Proposed creation of new 1st floor & raised tiled roof.

1 Downlands Close Pagham

Thank you for your internet representation made on 24th January 2013 which has been recorded as '**an objection**' with the comments as follows:

sheet 3 of 5

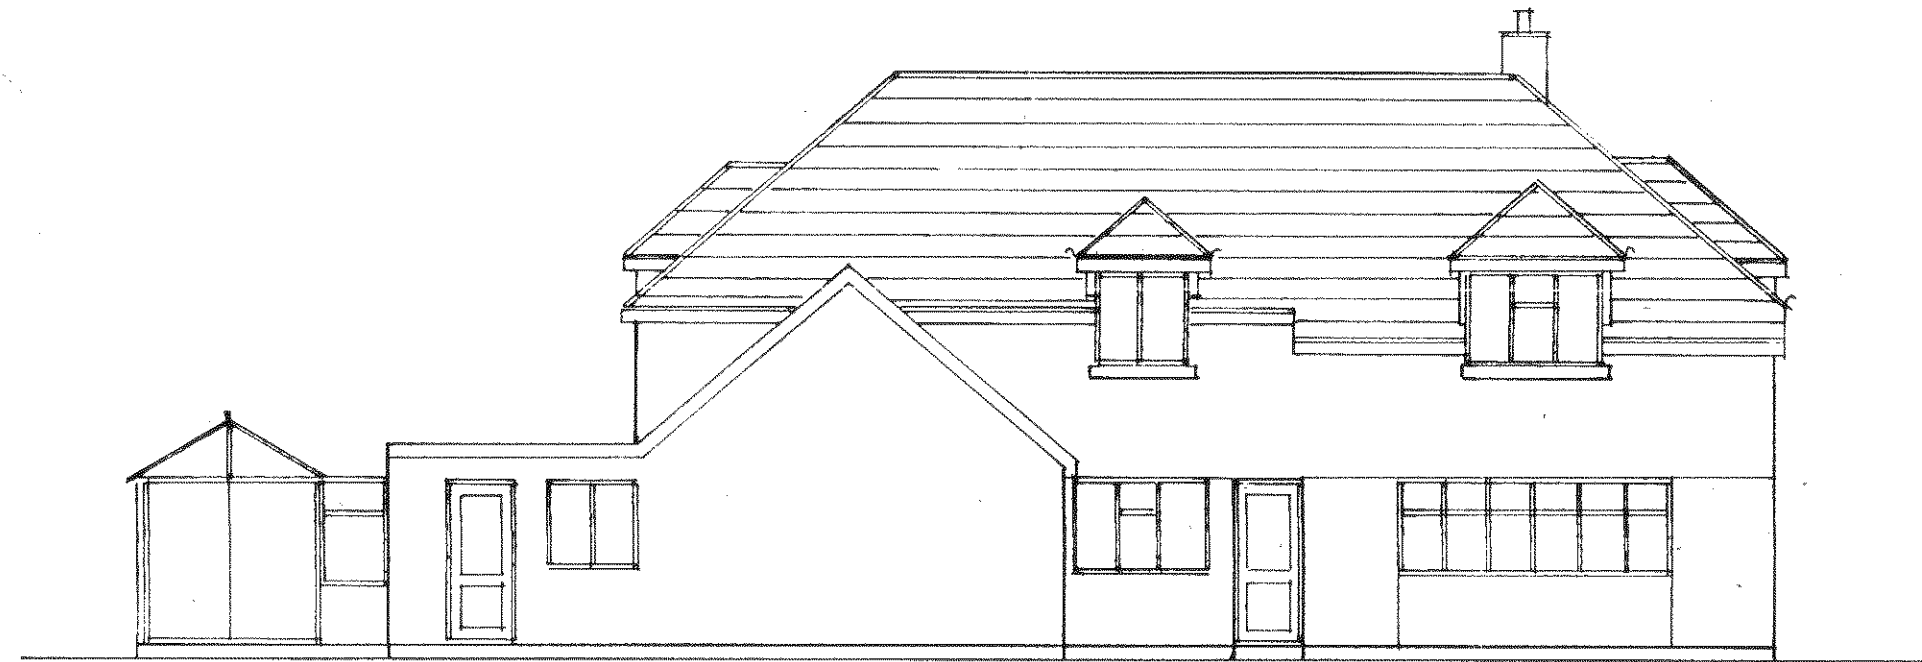
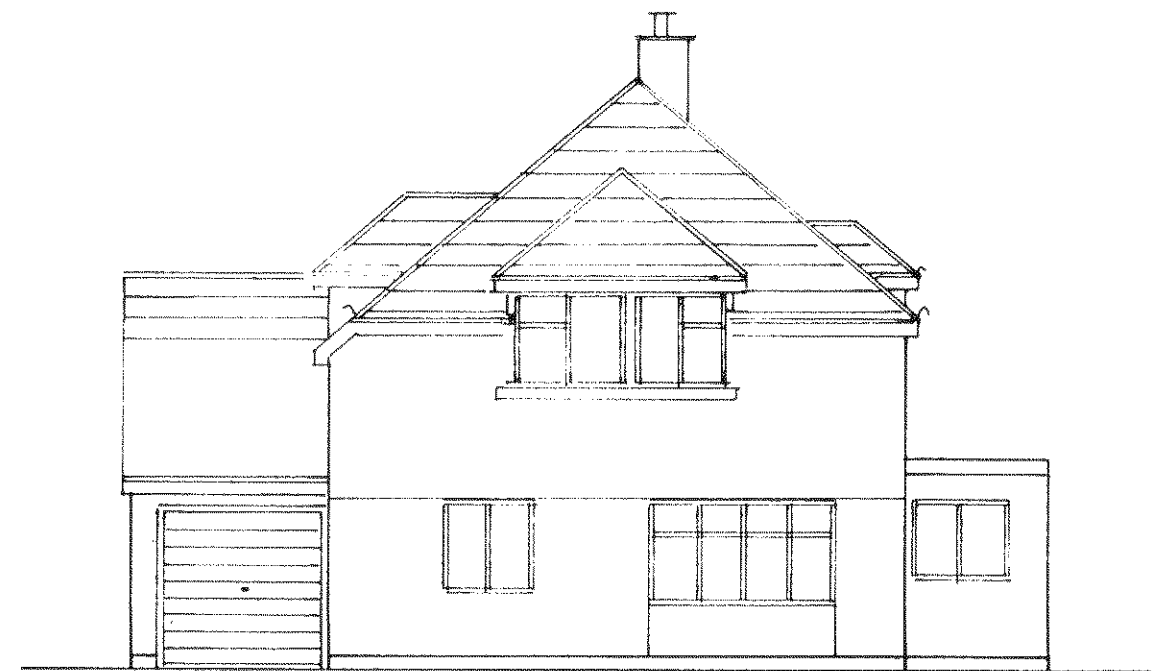
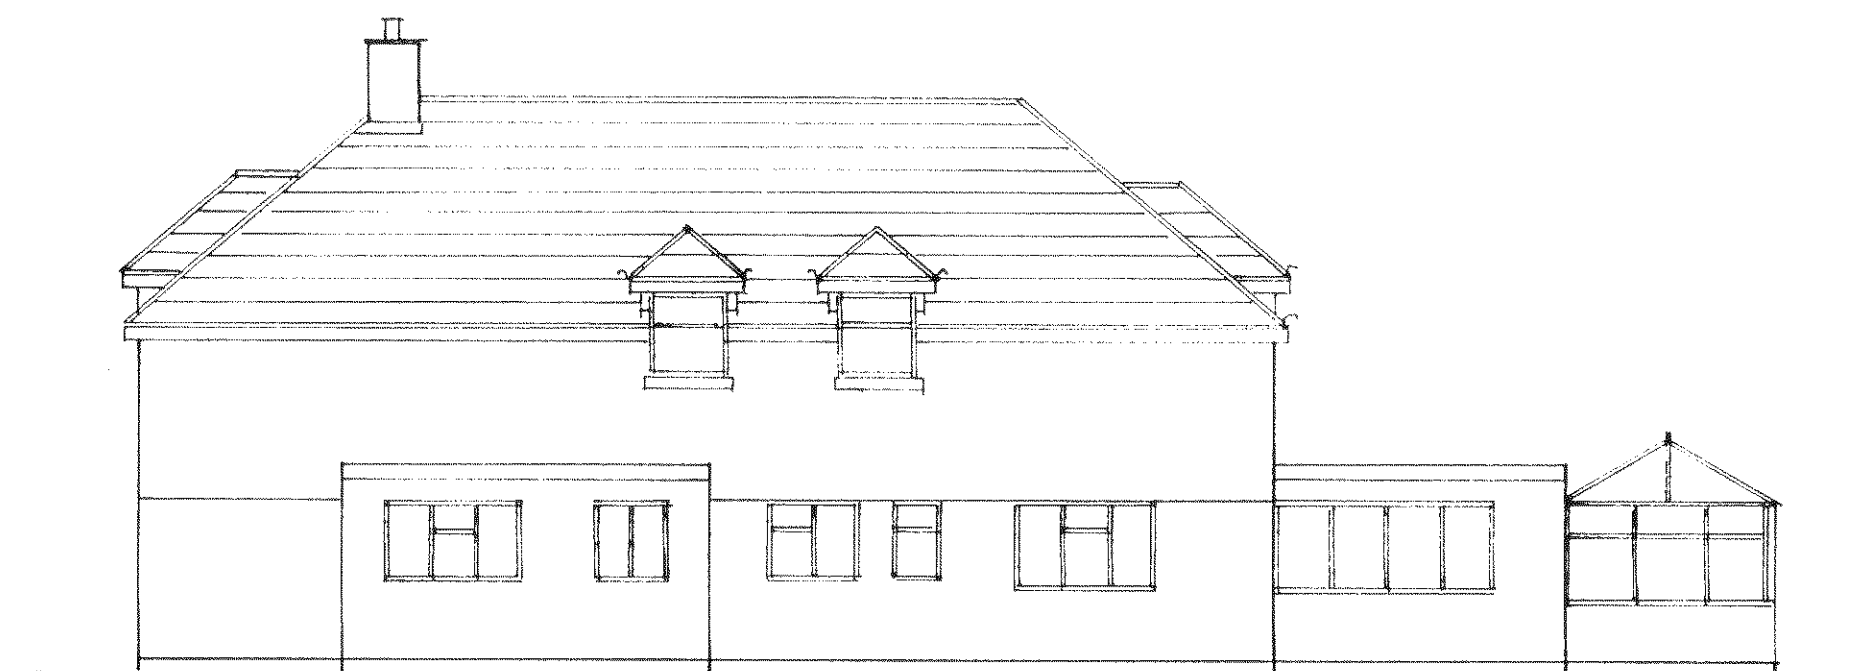
Comment was made of the height and bulk of the building being out of character with those in that locality, particularly in Downlands Close itself. Members reflected upon similar high level dormers consented at Fletcher Close having a seriously detrimental effect upon residents in Esher Close, which had been the subject of retrospective complaint to the Council by distressed retired folk at that location. Opinion was expressed that such a building would dominate the streetscape in an undesirable way at that entrance to the built up area of the village of Nyetimber which has been claimed to possess its own discrete and ordered identity.

Dev 19 (ii) √. √ visually subservient to the main building. √, (iii) √ adverse √. overlooking or overbearing effect on neighbouring properties √, (v) √ √ does not compromise established spatial character and pattern of the street √
